Application number: 2024/93144	
What is the application for?:	Erection of single storey extension to garage
Address of the site or building:	Brigsteer, 402, Birkby Road, Birkby, Huddersfield, HD2 2DN
Postcode:	HD2 2DN

User comments

drawing PROPOSED SITE PLAN AND ELEVATIONS

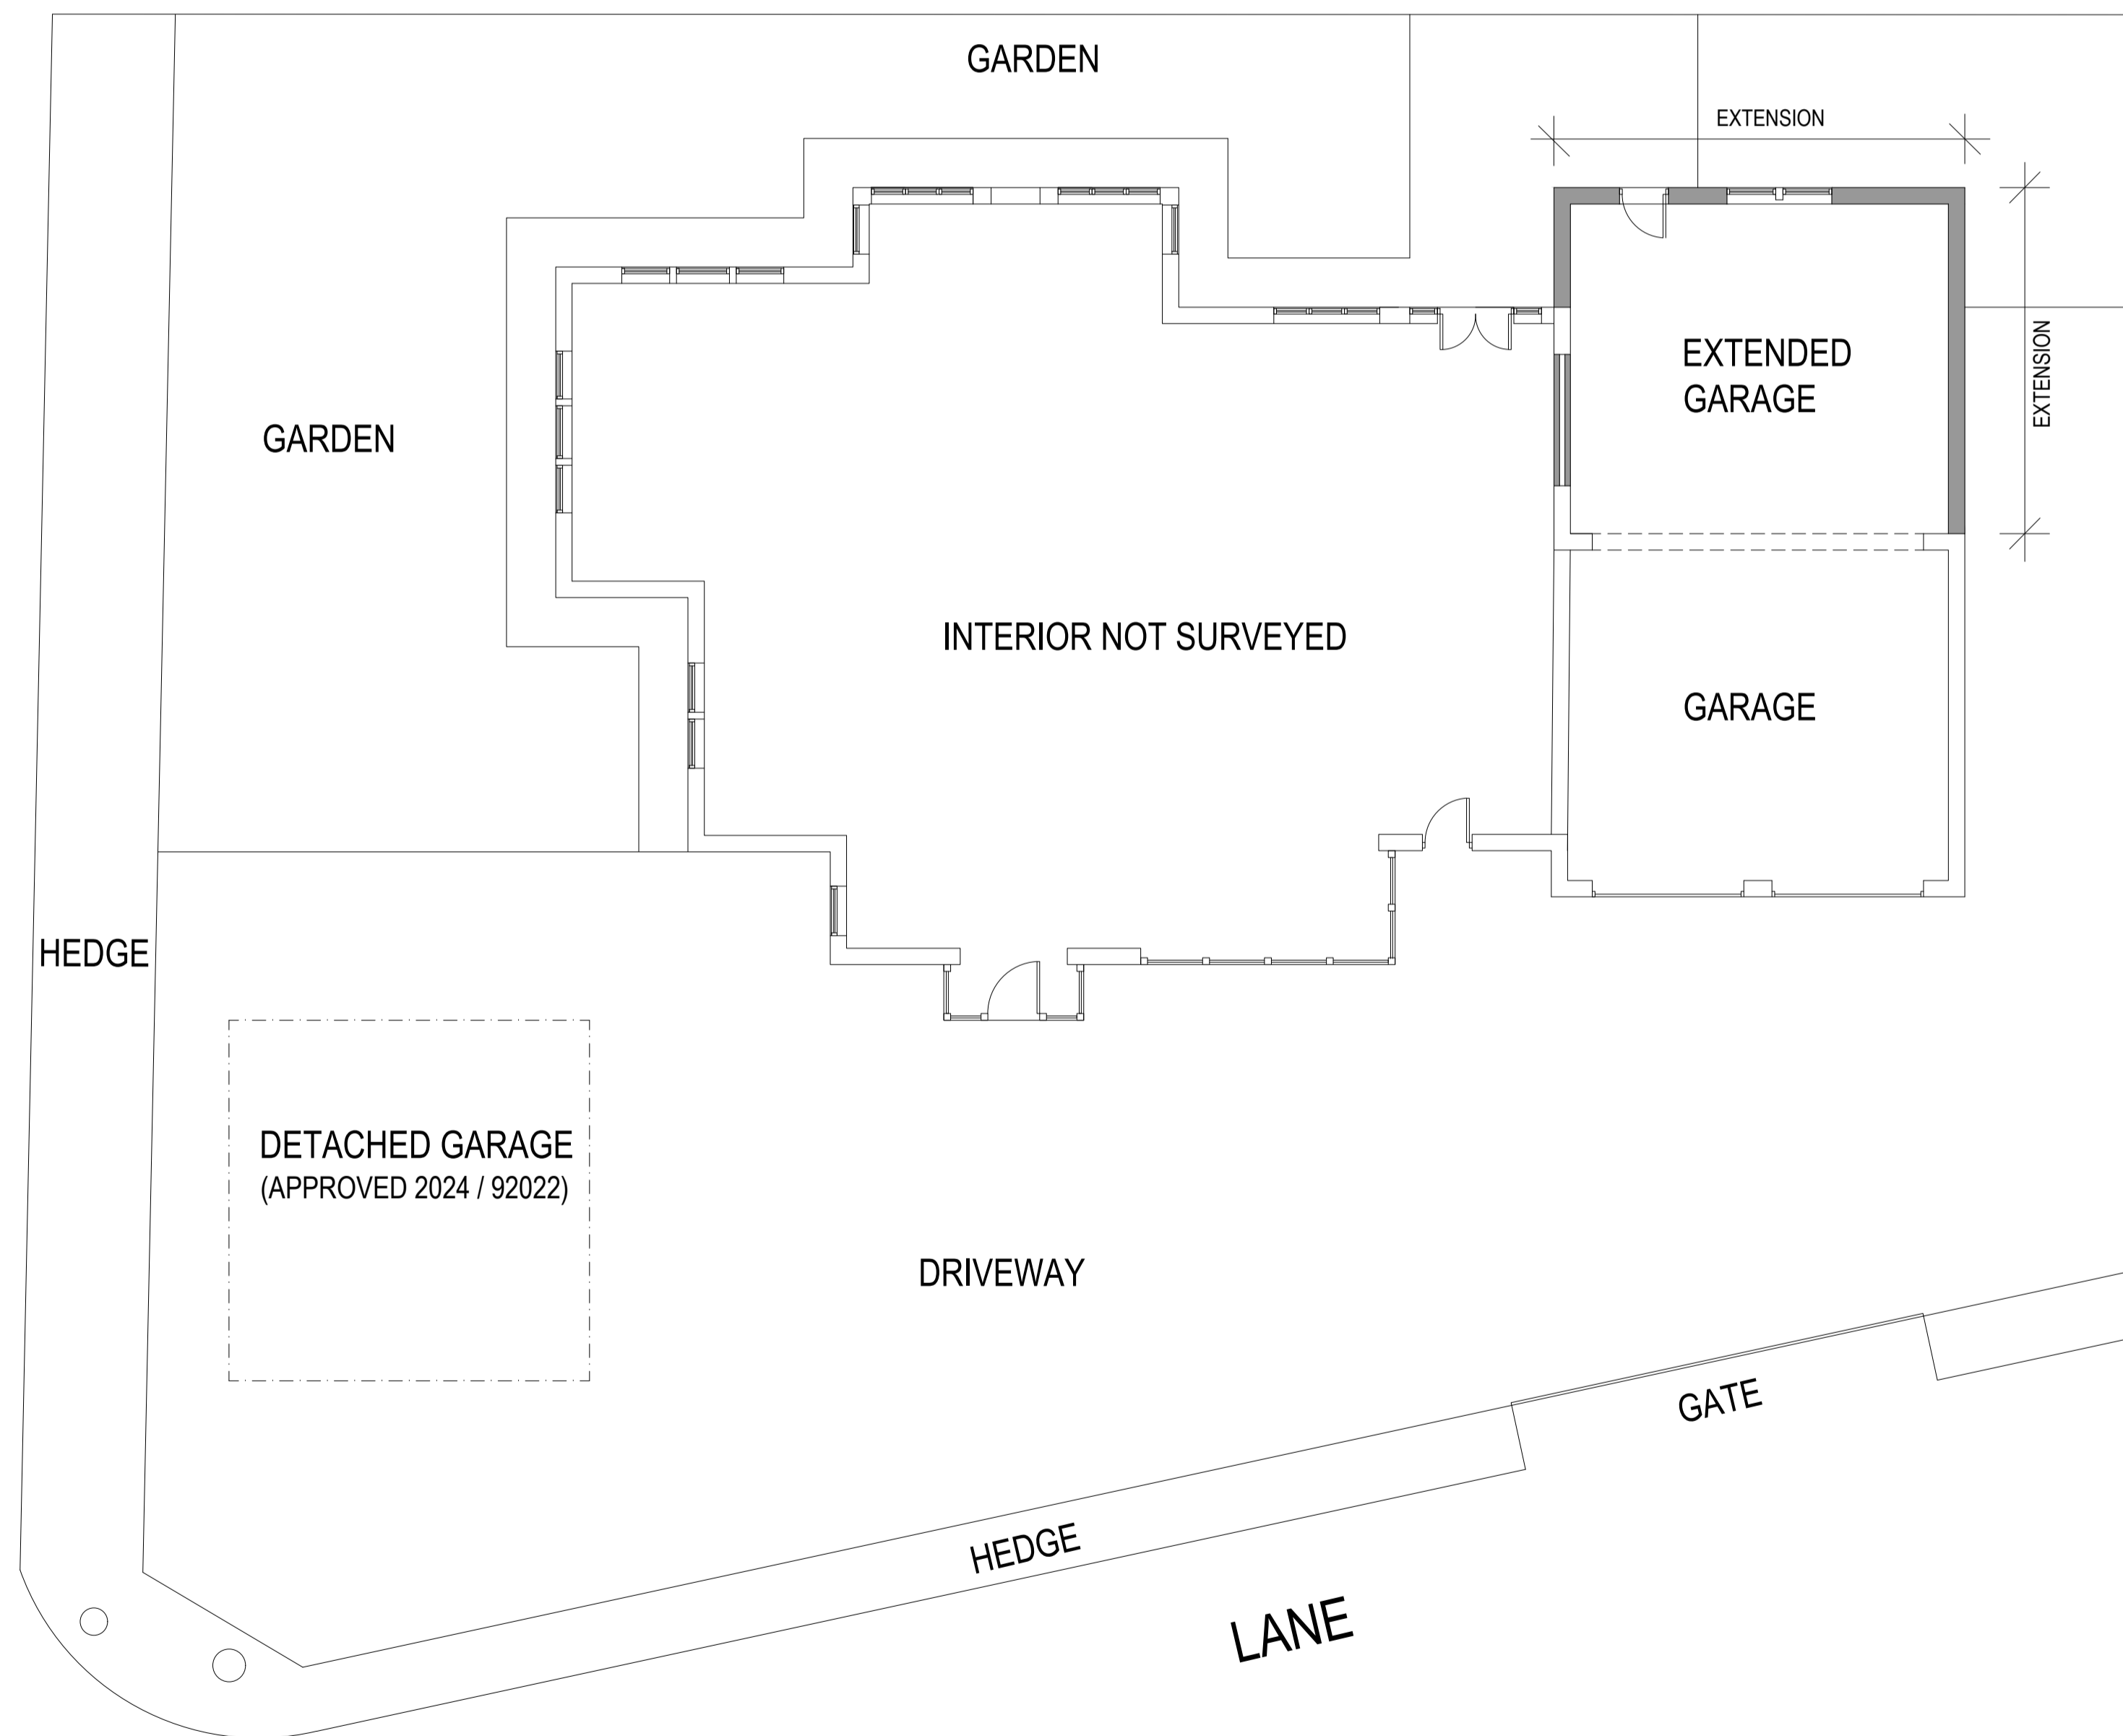
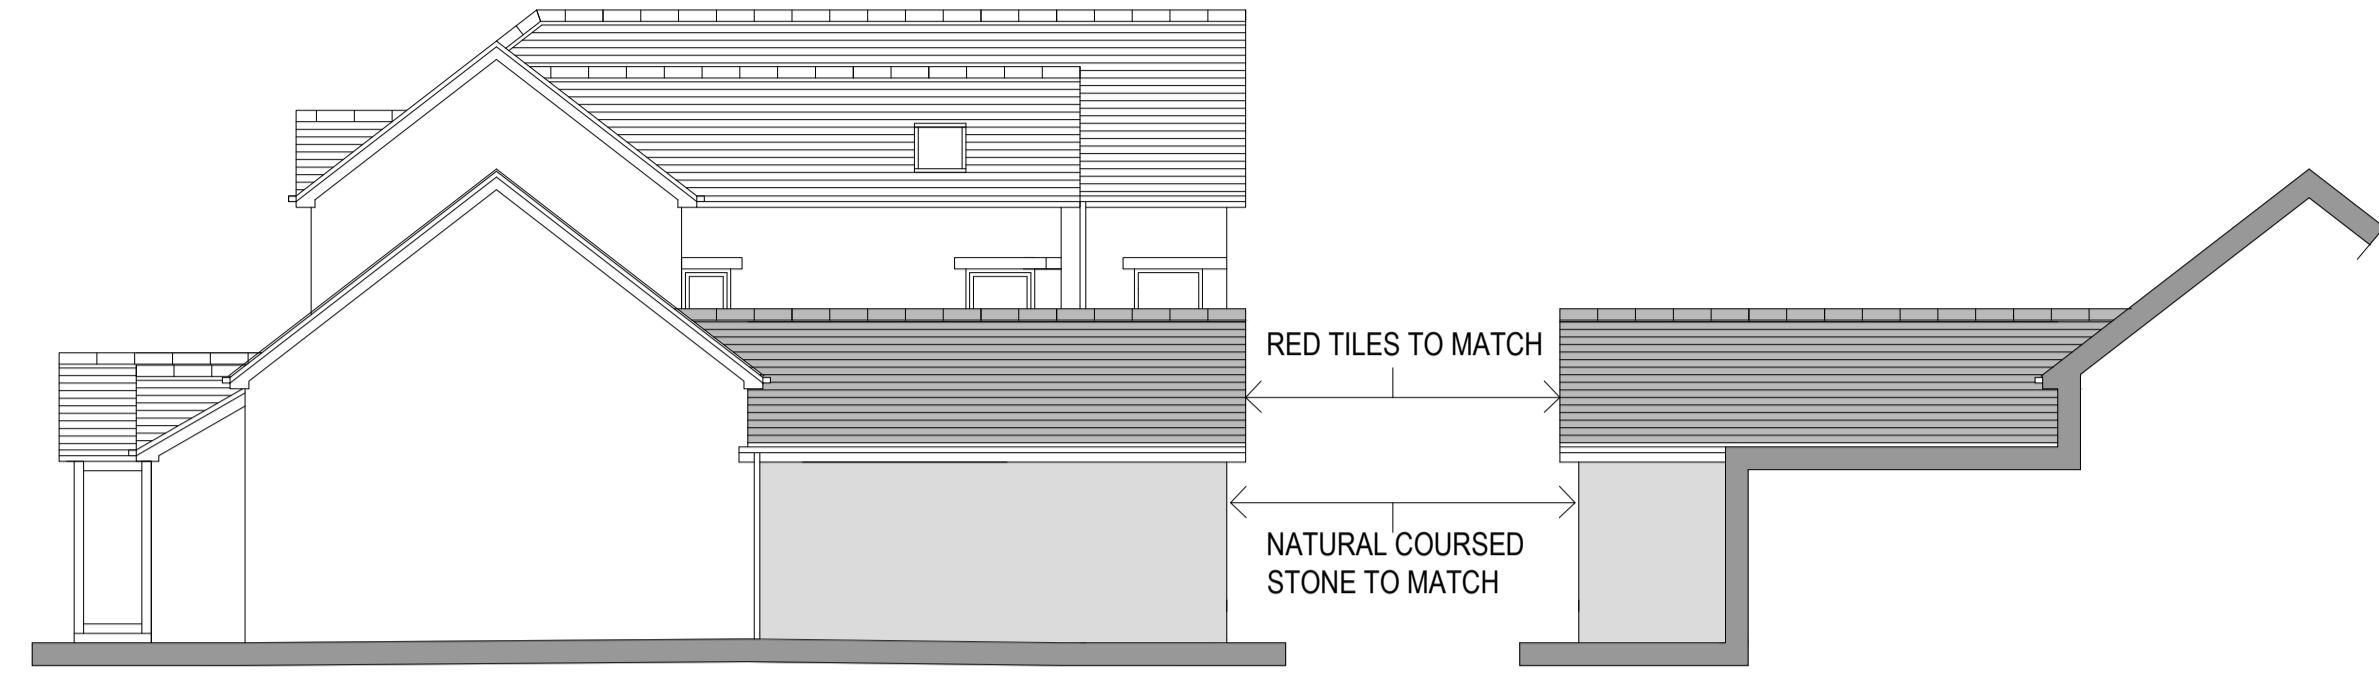
Type of comment: An objection	
Do you wish your comments to be published on the website anonymously?	Yes
The height of the extension is higher than the maximum permitted by the LPA in it's Extensions & Alterations Supplementary Planning Document. Section 5.6 states that single storey extensions should not exceed 4m in height.
